M. NICHOLS
4 QUEENS FIELDS EAST
WEST MEADS
WEST SUSSEX
PO21 5RN

PLANNING.. AW/161/18/HH

Proposed Ground Floor

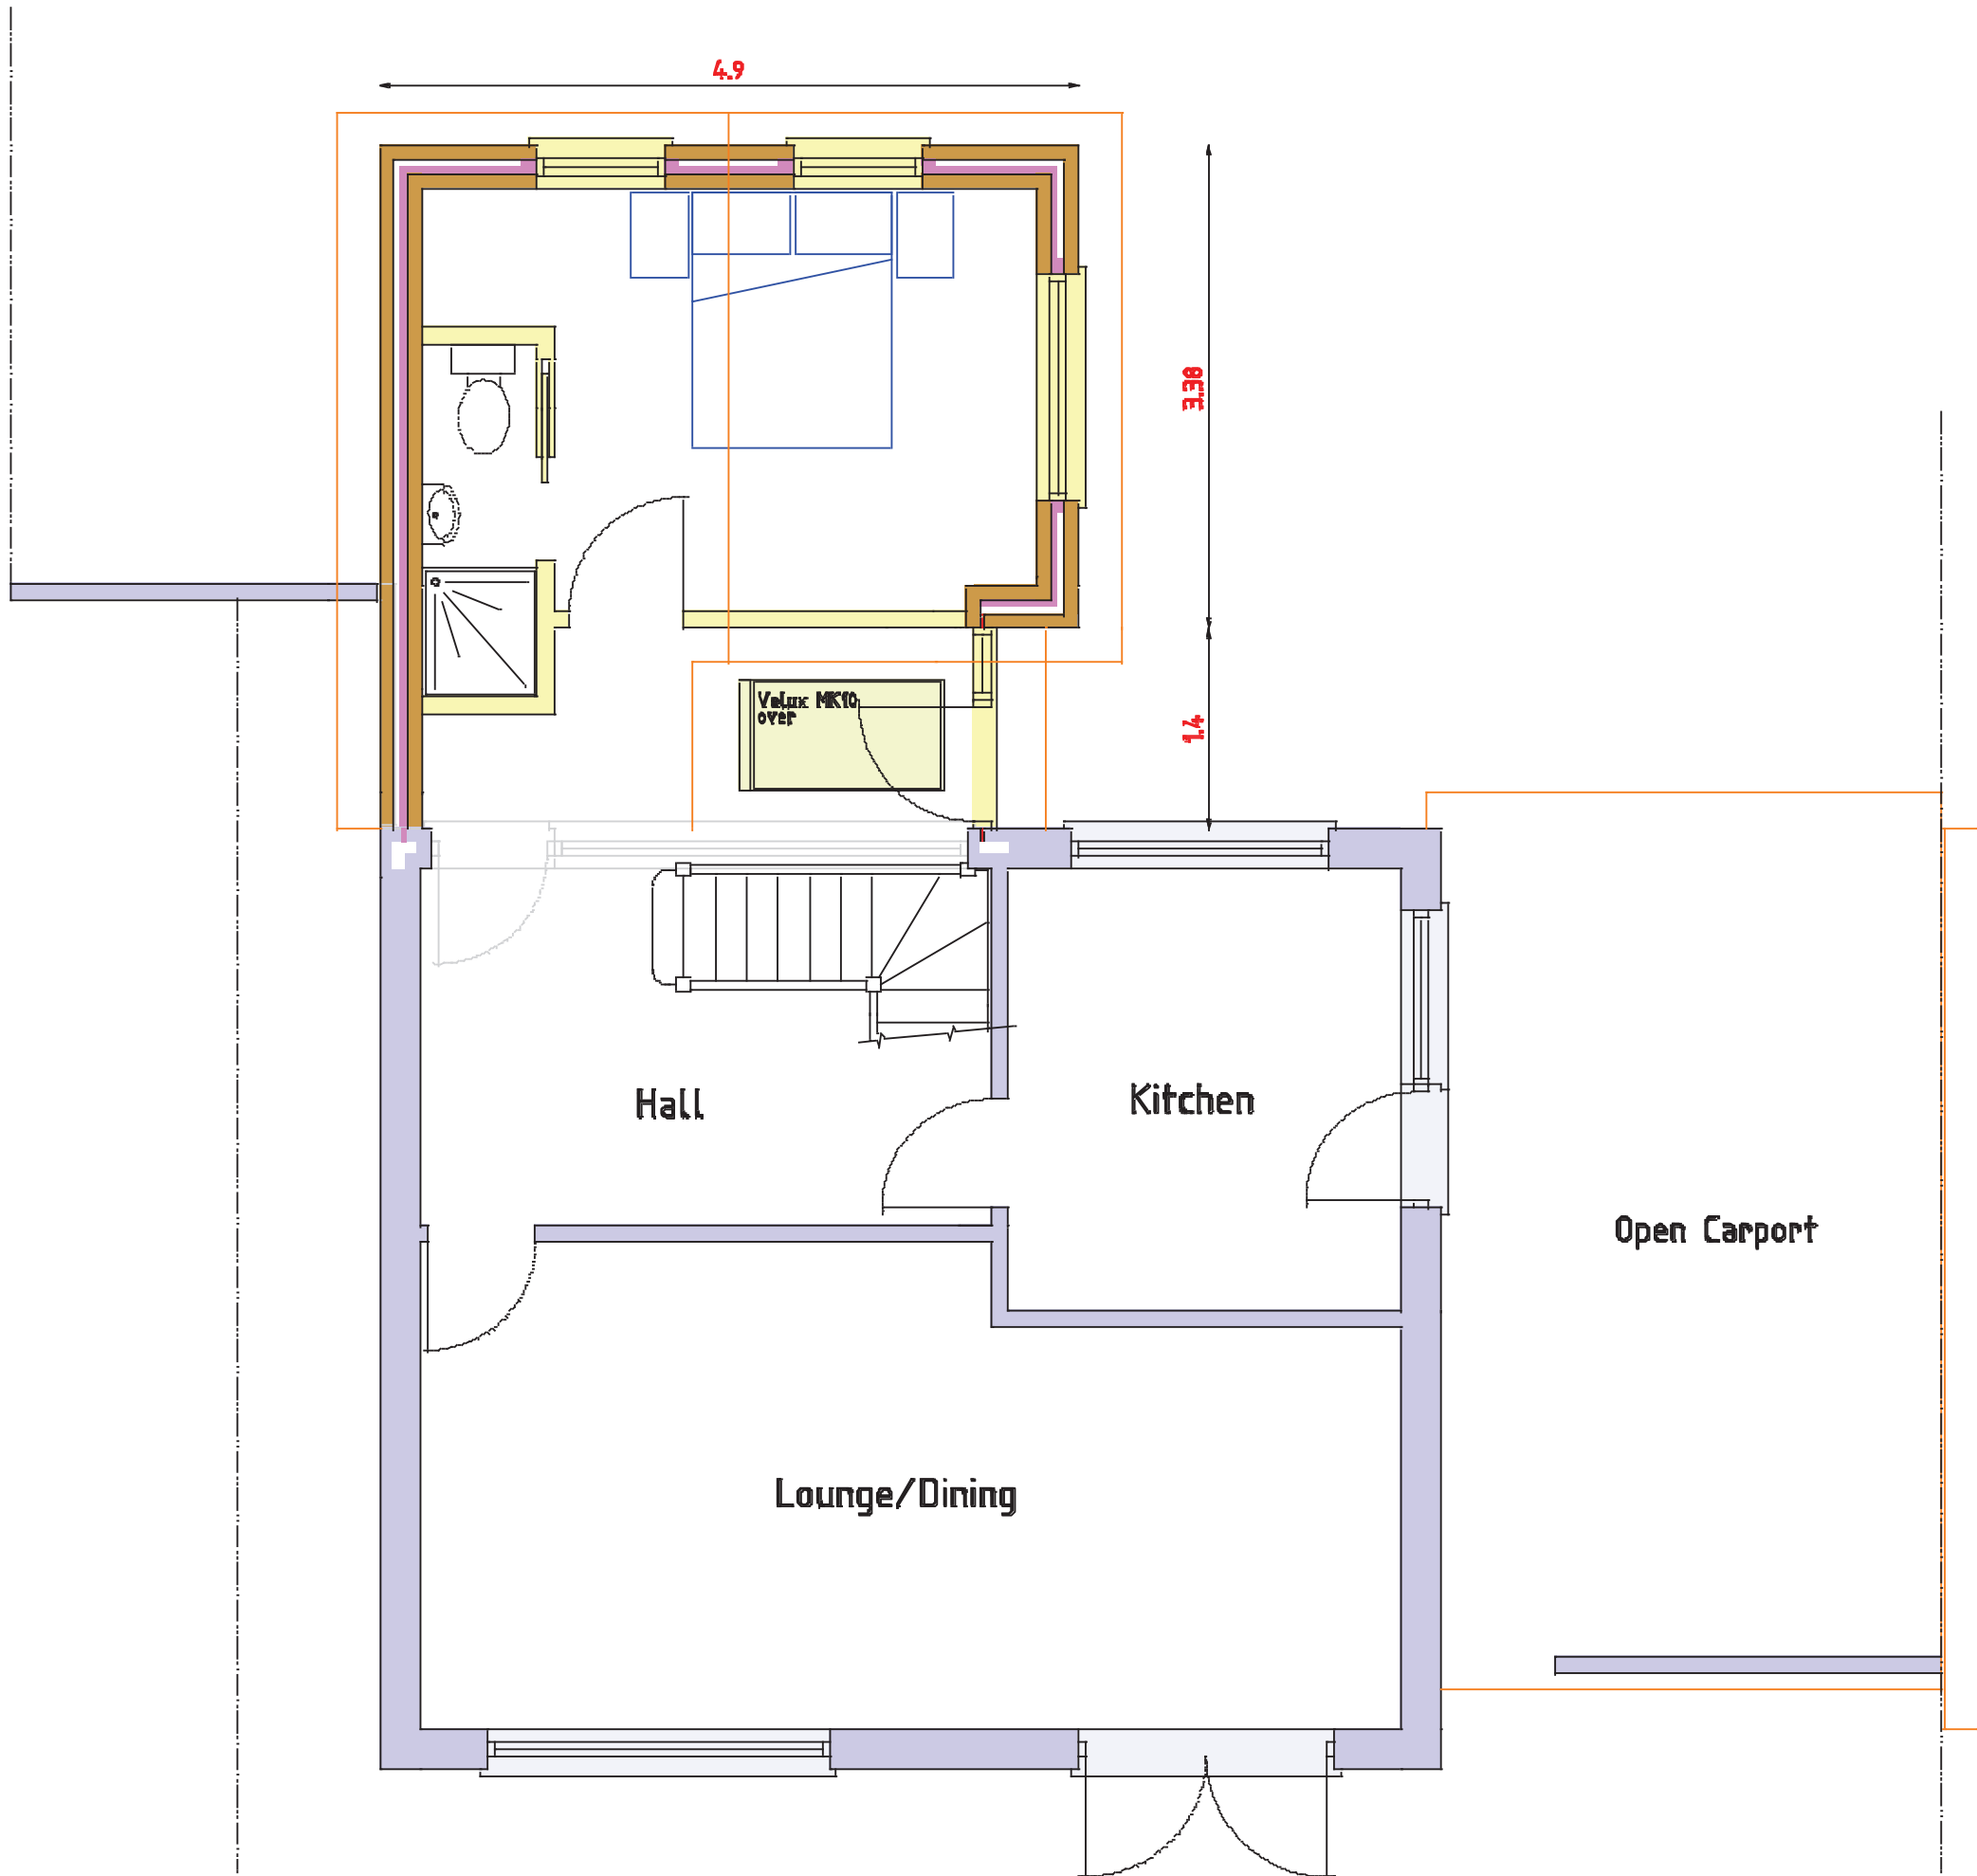
I object to this single storey front extension on the grounds that the scale is out of character with the rest of the estate as it projects out some 4.78 mts from the front of the house and some 4.9 mts wide. West meads is an open planned estate. Large developments to the front of houses & bungalows would be contrary to saved policies GEN7, Dev19 of the local plan and the adopted parish design statement.
